St Marys Intermodal (SSD-7308)
Request for Additional Information

The Department has reviewed the St Marys Freight Hub – Noise and Vibration Impact Assessment (NVIA), Post Exhibition Version, dated 11 February 2020 (AECOM Australia Pty Ltd).

## APPENDIX 2 NOISE WALL LOCATON (RED LINE)

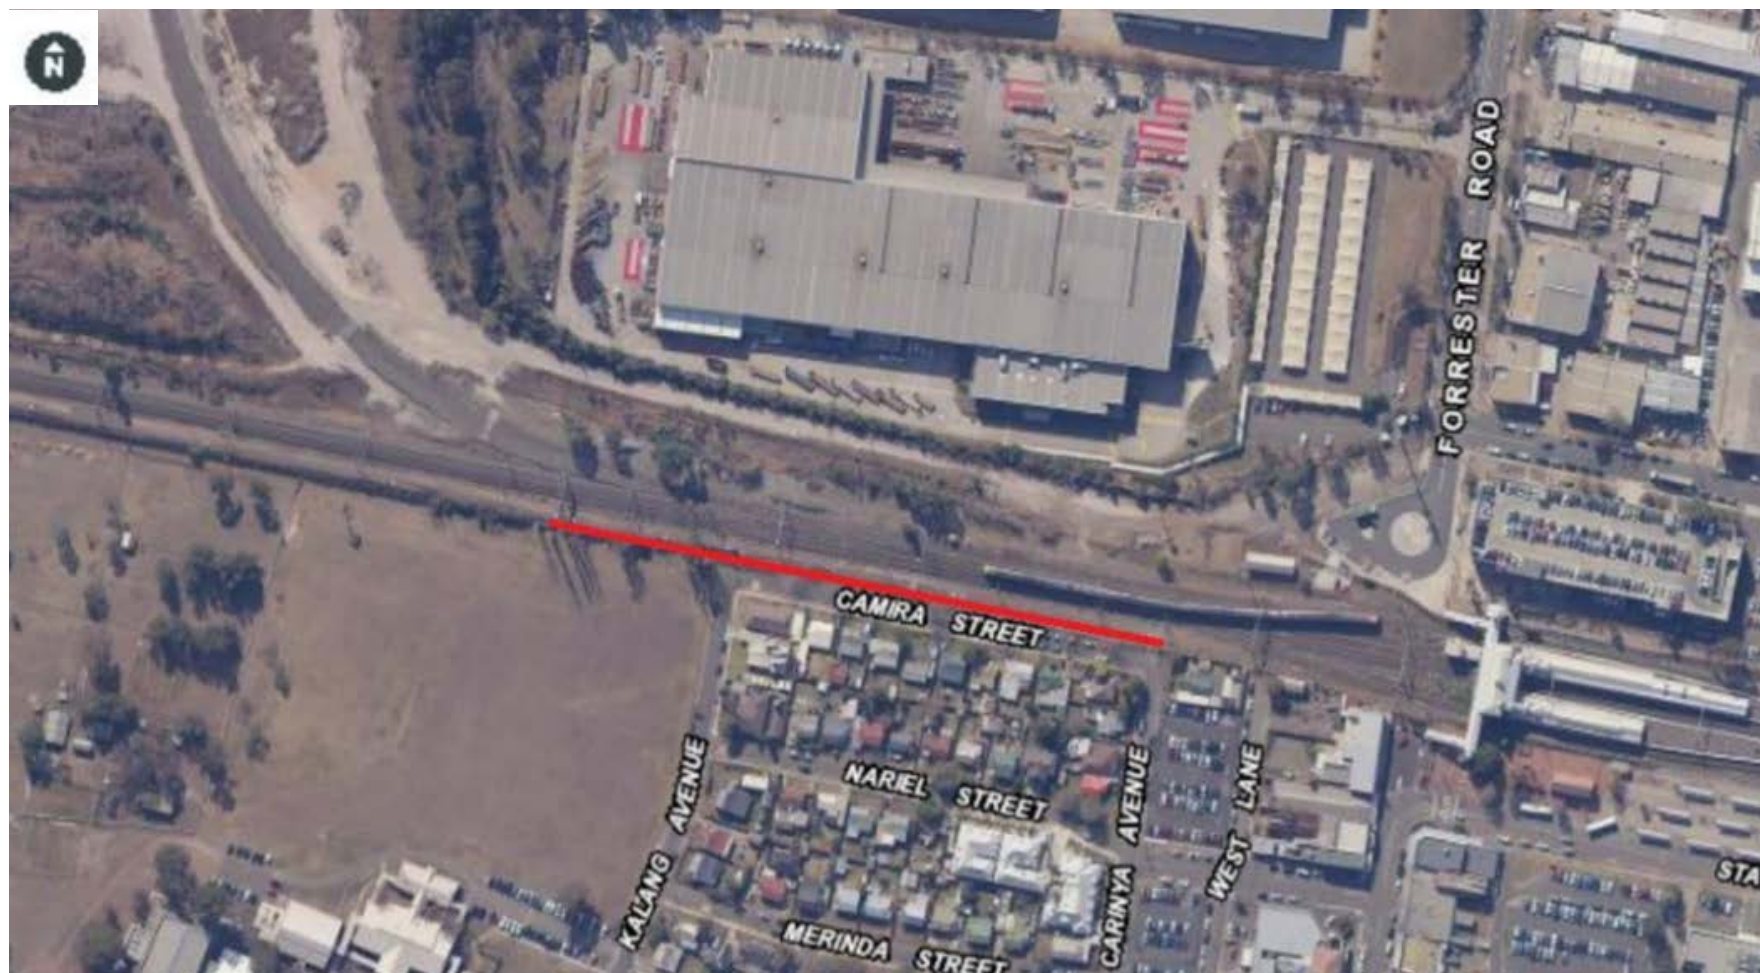
- provide a model of project noise attenuation provided by a 2.4m noise barrier in the position outlined in red below (see **Attachment 1**). Please also provide a model that captures a 1.2m addition to the noise barrier (i.e. 3.6m noise barrier) and compare these predictions against those made in the Post Exhibition version of the NVIA

- provide an estimate of changes in exposure of residences in Kalang Avenue/Camira Street to the existing rail traffic, as a secondary consequence of the southern noise barrier location (both 2.4m and 3.6m options)

- quantify the residual excess noise impacts from the southern noise barrier options (both 2.4m and 3.6m options) and compare against those provided for the northern noise barrier location

- discuss the two noise barrier locations (both northern and southern) in terms of changes to the overall noise catchment (i.e. cumulative noise from both industrial and operational rail impacts).
